CITY OF ALBUQUERQUE

June 9, 2023

**Re: Mesa Del Sol Montage 7
Erosion and Sediment Control Plan
Engineer's Stamp Date 5/11/2023 (C09E014)**

TEMPORARY EROSION AND SEDIMENT CONTROL PLAN

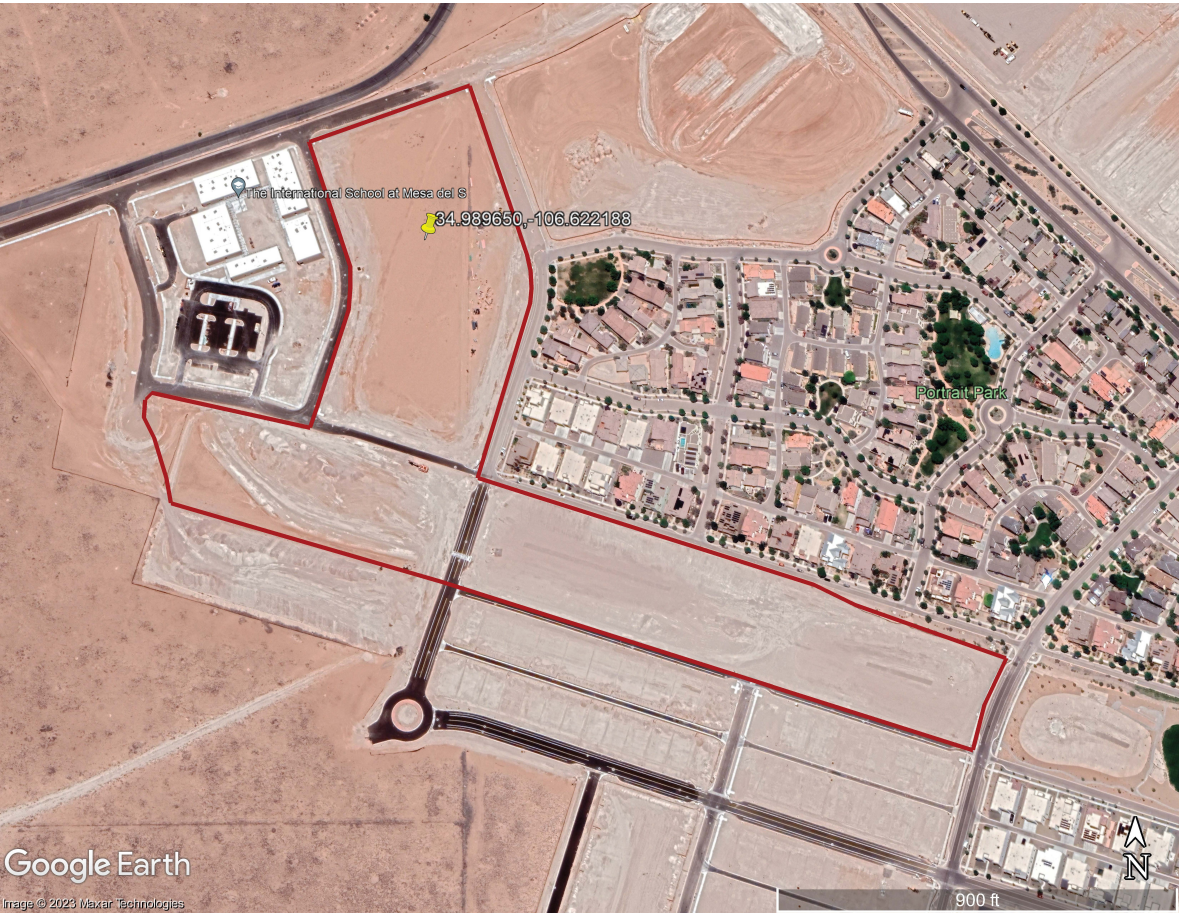
1. The ESC Plan can't be approved until after Hydrology approves the G&D Plan for each specific purpose, Site Plan, Grading, Building Permit, and Work Order. The only purpose Hydrology has approved so far is Rough Grading and Infrastructure. The existing and proposed grades must be shown on the ESC Plan, and they must agree with the Grading Plan approved by Hydrology (CGP7.2.4.b.ii).
